A/44/26/PL

One factor that appears to have been overlooked, and which relates directly to the concern you expressed in your email to the Secretary of State regarding the impact upon residents, is how the proposed reconstruction of SA1 is intended to be undertaken.

Scale	Date	Designed
1:200 @A1	JUL 2025	AK
Drawn	Checked	Approved
AK	BO	BAC
Job No	Drawing No	Rev
21-254	21-254-701	D

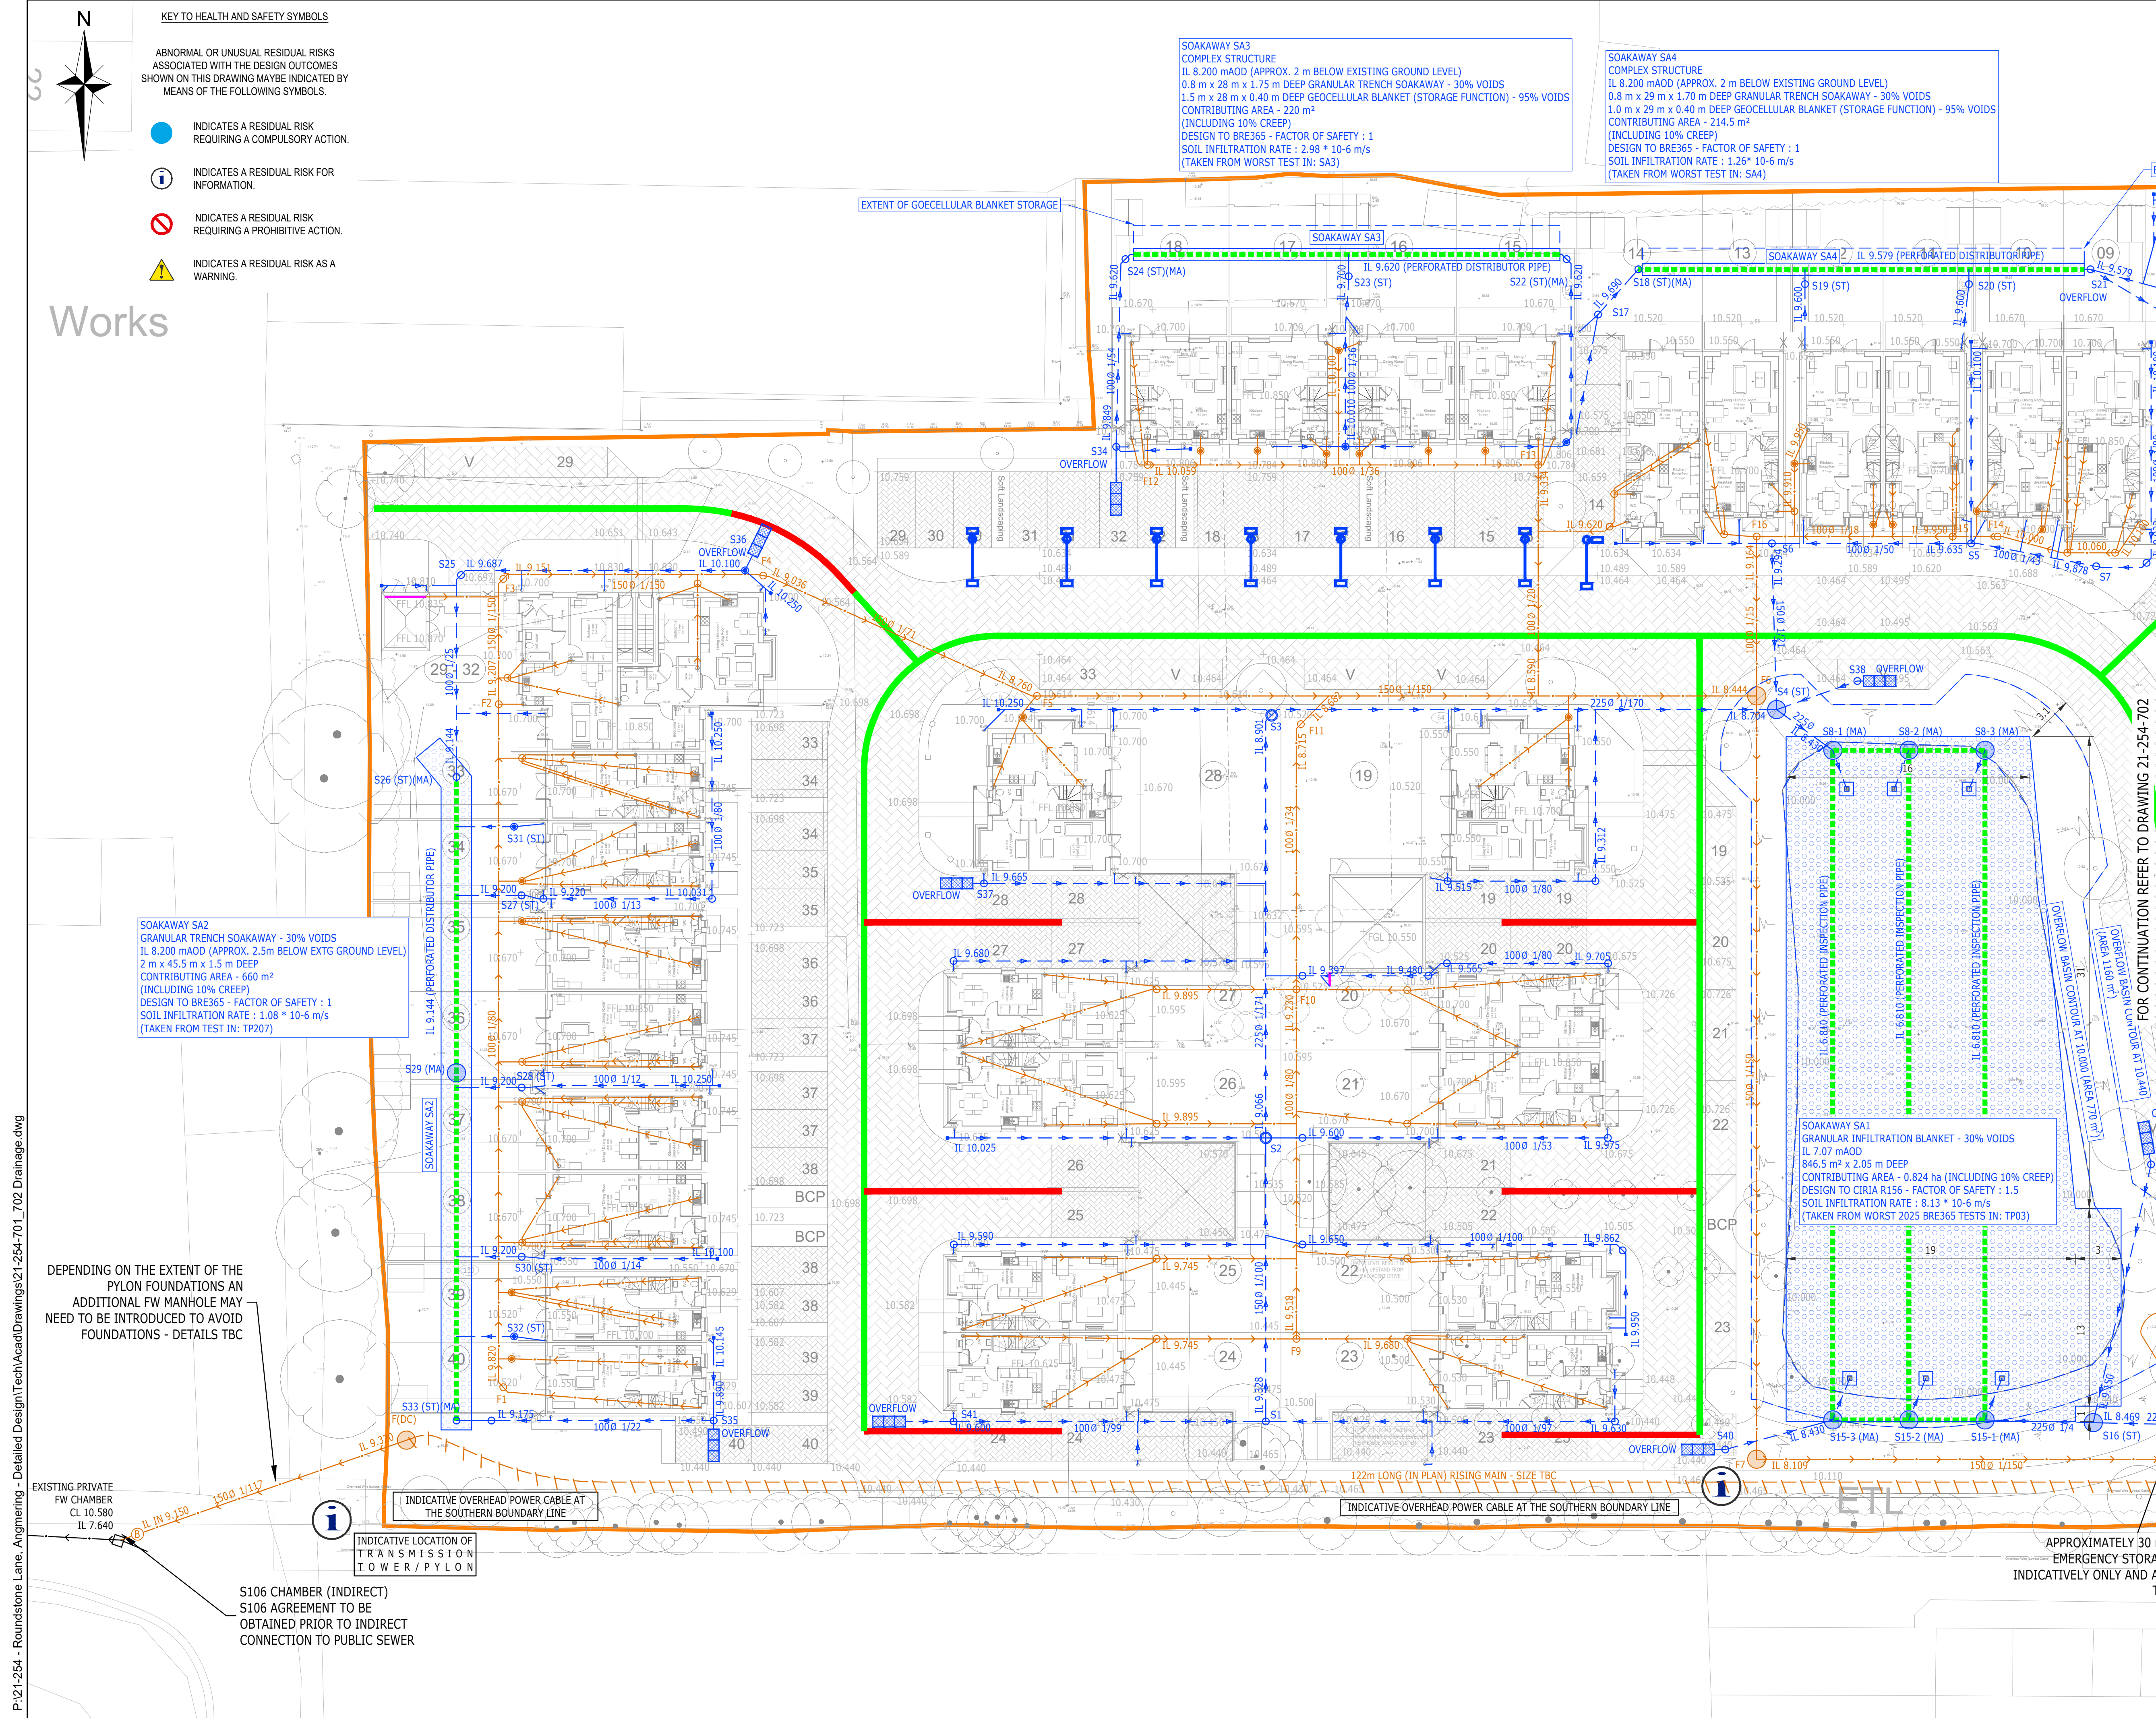
Taking the figures shown on the submitted drawings, excavation of the existing SA1 would involve removing approximately 4,000 tonnes of material, based on an indicative bulk density of approximately 1.7 tonnes per cubic metre.

SA1 area: 846.5 m²

Depth from ground level to revised SA1 invert: 10.000 – 7.070 = 2.930 m

Excavation volume: 846.5 × 2.930 = 2,480.245 m³

Indicative mass: 2,480.245 × 1.7 = 4,216.417 tonnes

That equates to at least 200 fully loaded 20-tonne HGVs removing material from the site, and substantially more if vehicles of only 10- or 15-tonne capacity are used. A broadly similar number of loaded HGVs would be required to import replacement material, resulting in approximately 400 loaded HGV movements if 20-tonne vehicles are used, rising to as many as 800 if limited to 10-tonne vehicles, before allowing for construction plant, ancillary deliveries and temporary storage requirements.

The reconstruction itself is also likely to require significant temporary works, potentially including sheet piling, to retain the sides of the excavation within an occupied residential development.

- The nature of any temporary retaining works required to facilitate the excavation, including the potential impact of vibration on nearby residents and the risk of resultant damage to adjoining properties.

- How the proximity of the excavation to the existing estate road has been assessed and how the stability of the carriageway will be protected.
- How the existing permeable paving, which already exhibits signs of rutting under normal residential traffic, will be protected from repeated heavy construction traffic and what reinstatement is proposed should damage occur.
